From: Borough Planning
Sent: 05 January 2023 09:26
To: [REDACTED]
Subject: RE: Invalid Letter 22/02027/F

Ref: 22/02027/F

Rev	Description	Date
<b>Client</b>	: Mr & Mrs Cooper	
<b>Job title</b>	: Anvil, Main Road, Wisbech, PE14 9JR	
<b>Drg</b>	: Proposed Elevations	
<small>scale</small>	1:100	<small>date:</small> Oct 2022
<small>@ A3</small>		<small>drg. no.</small> A400-09

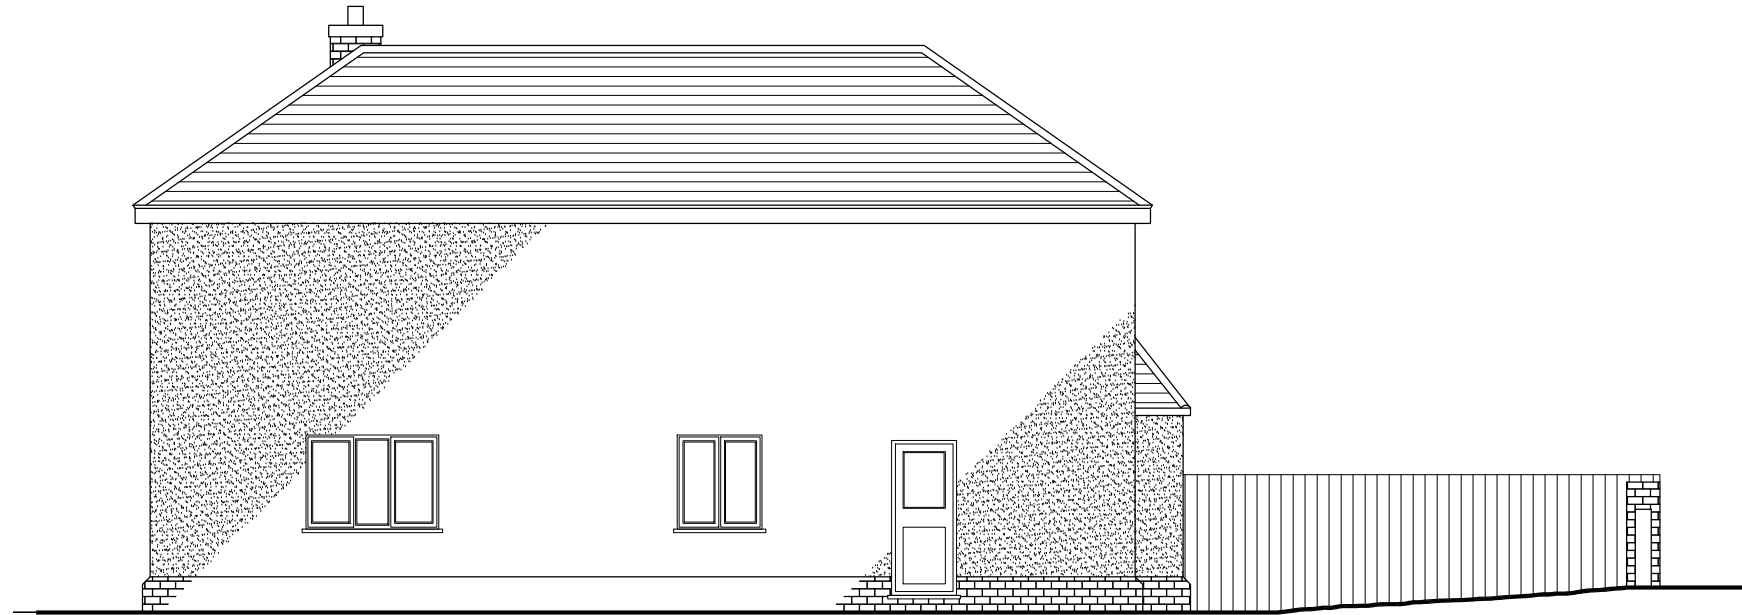
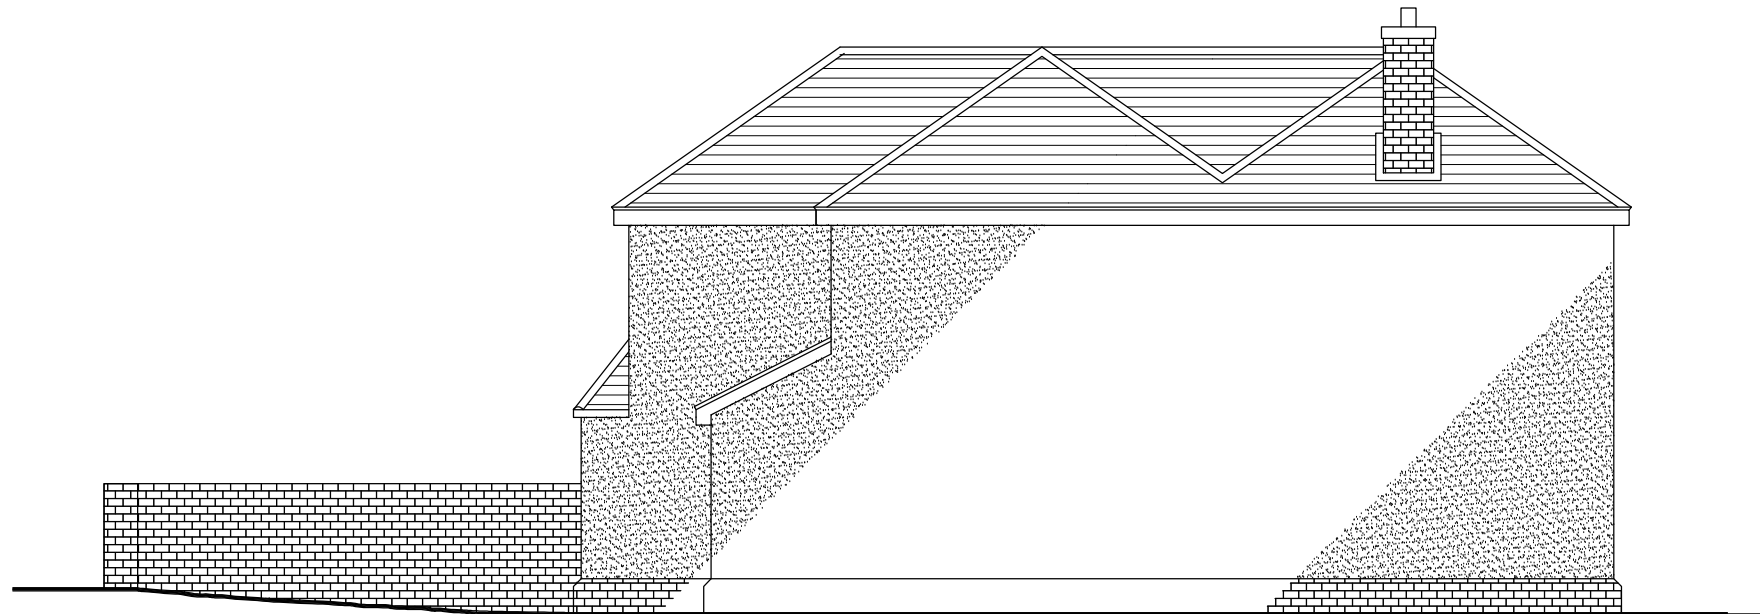
Dear Mr Cooper,
Thank you for your email and attachments. I have reviewed the documents submitted and have accepted the new information regarding the dropped curb. However I have noticed that you appear to have labelled all of the elevations as front. Please could you name each elevation accordingly i.e. front, rear, side etc. This will help to avoid confusion and possible delays when the application reaches the planner.

Rev	Description	Date
Client : Mr & Mrs Cooper		
Job title : Anvil, Main Road, Wisbech, PE14 9JR		
Drg : Site Location Plan (visibility splays)		
scale 1:200,1:1250 date: Oct 2022 drg. no. A400-11

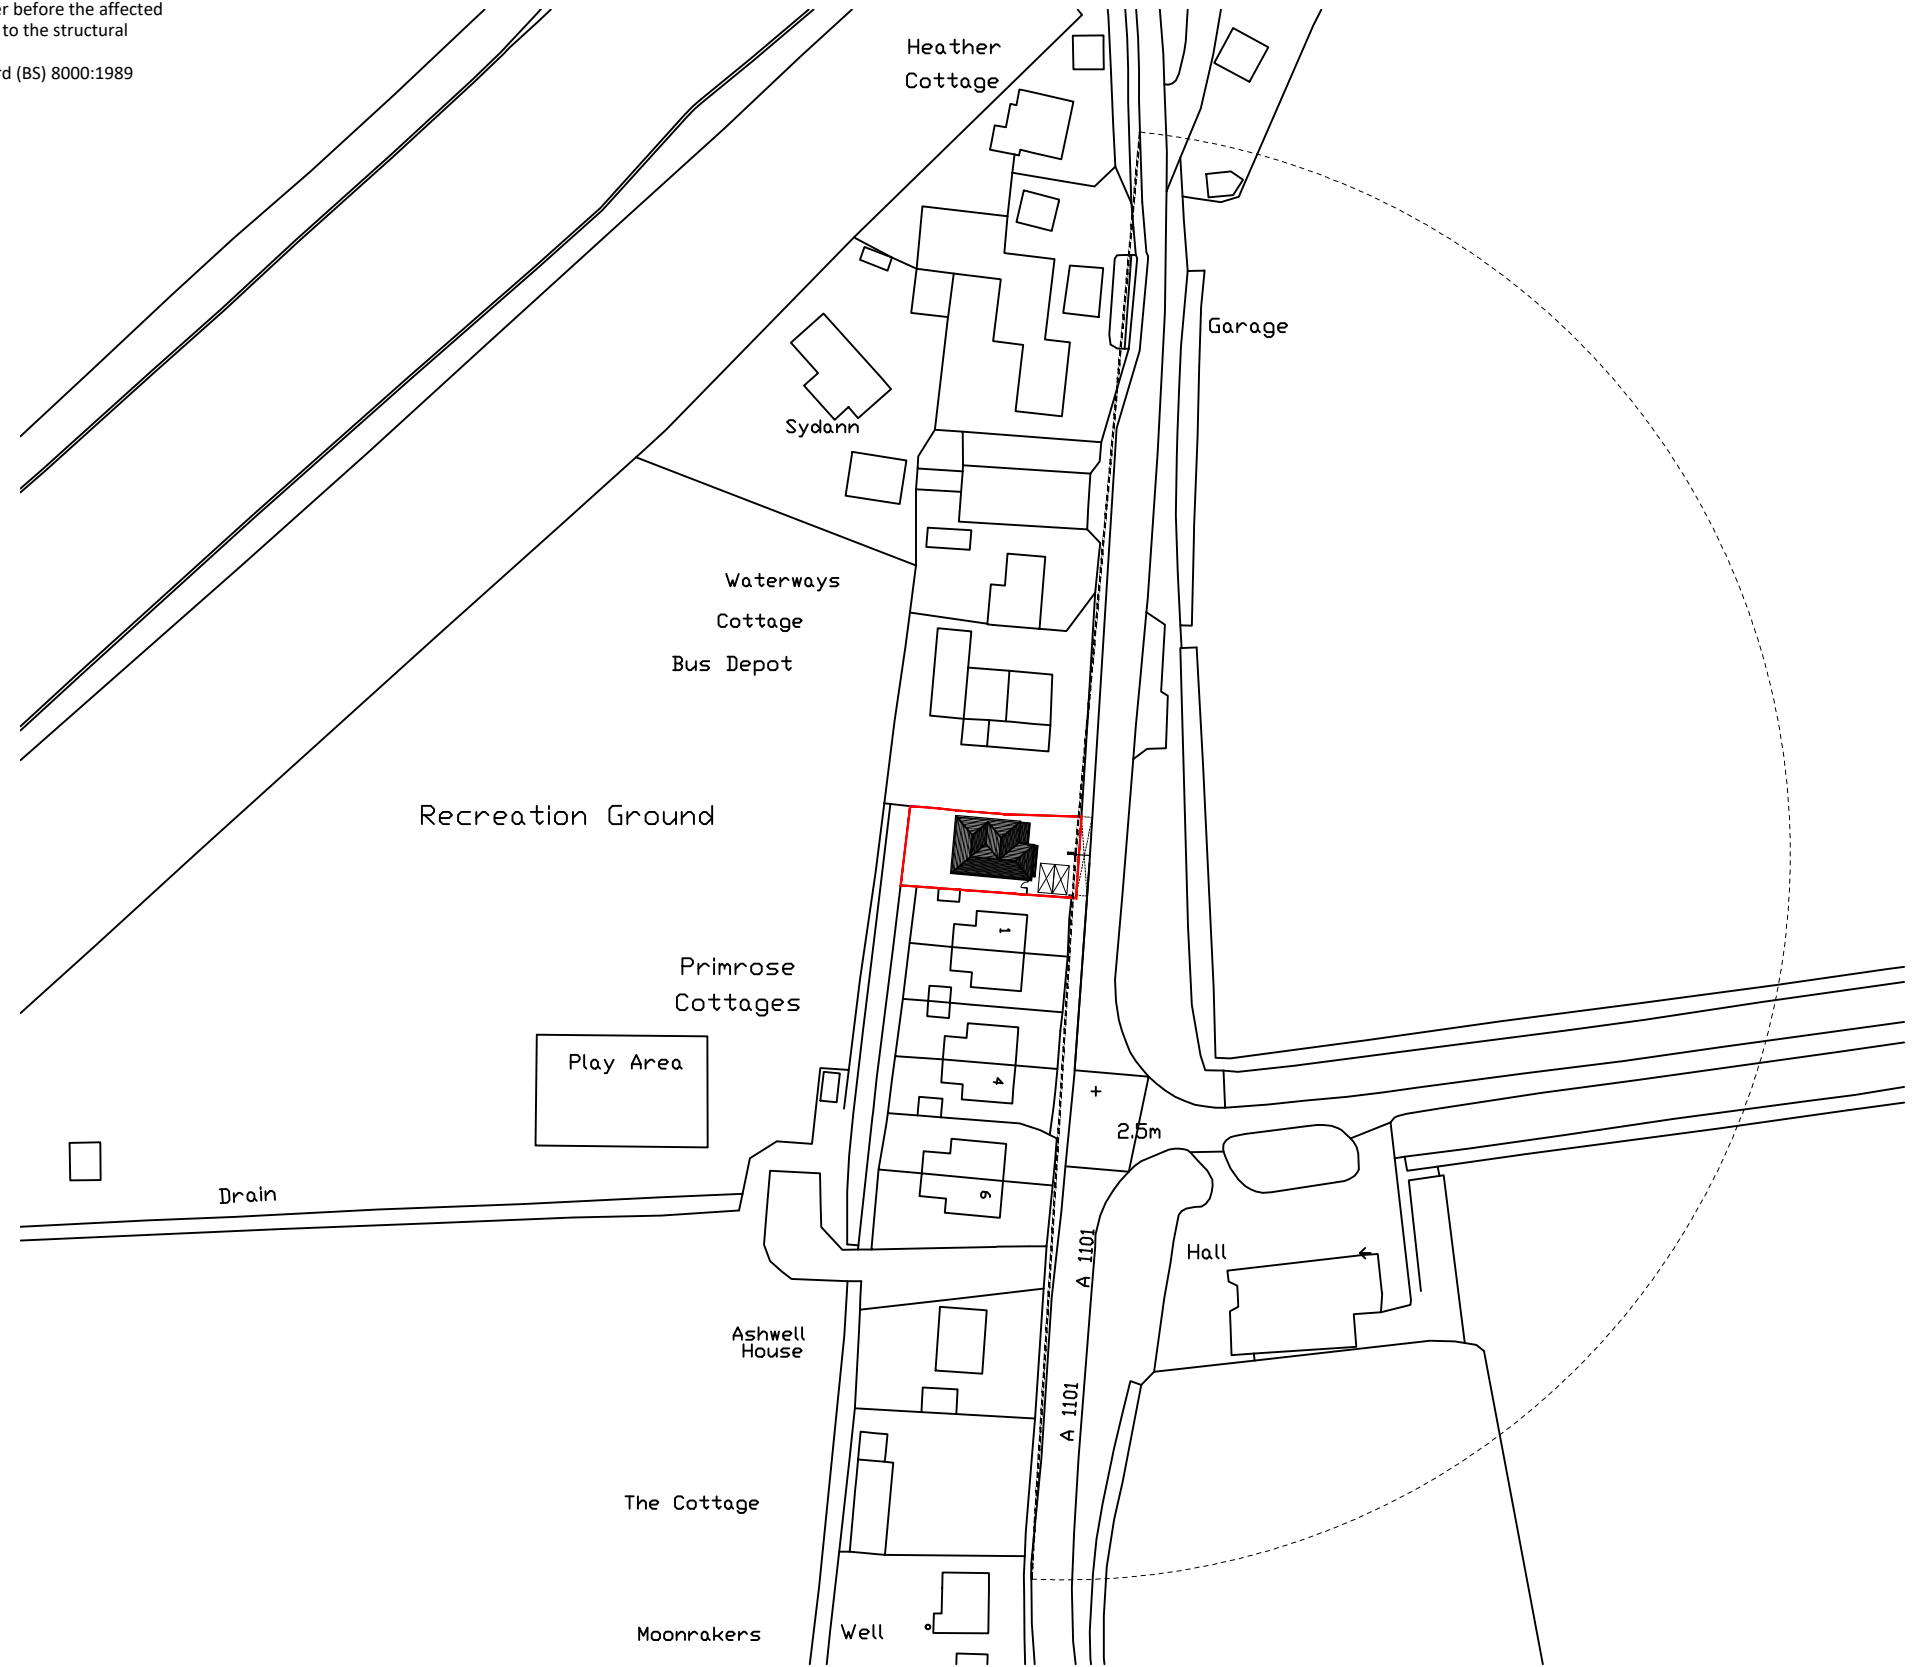
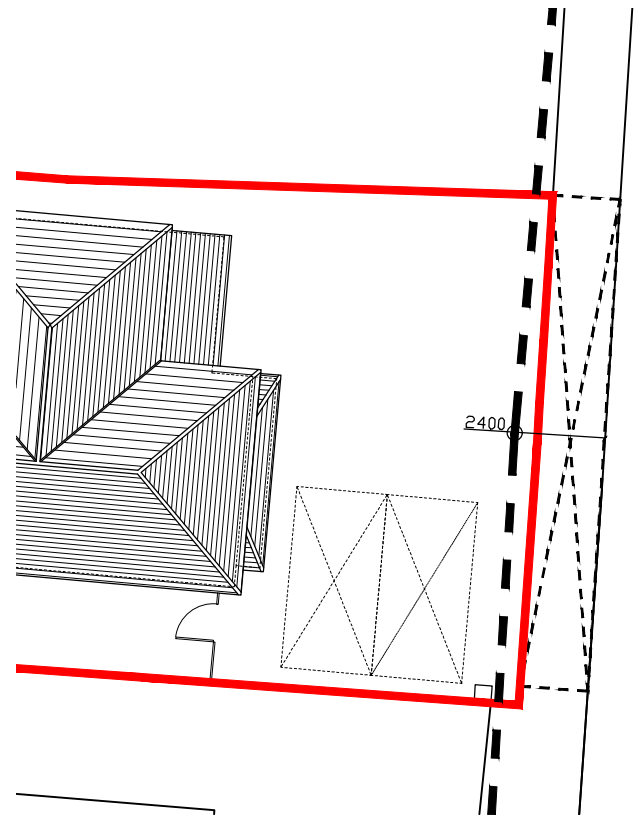
We have filled out a full application on the planning portal as requested. This includes an amended drawing A400-11 which shows the location and width of the proposed drop curb.
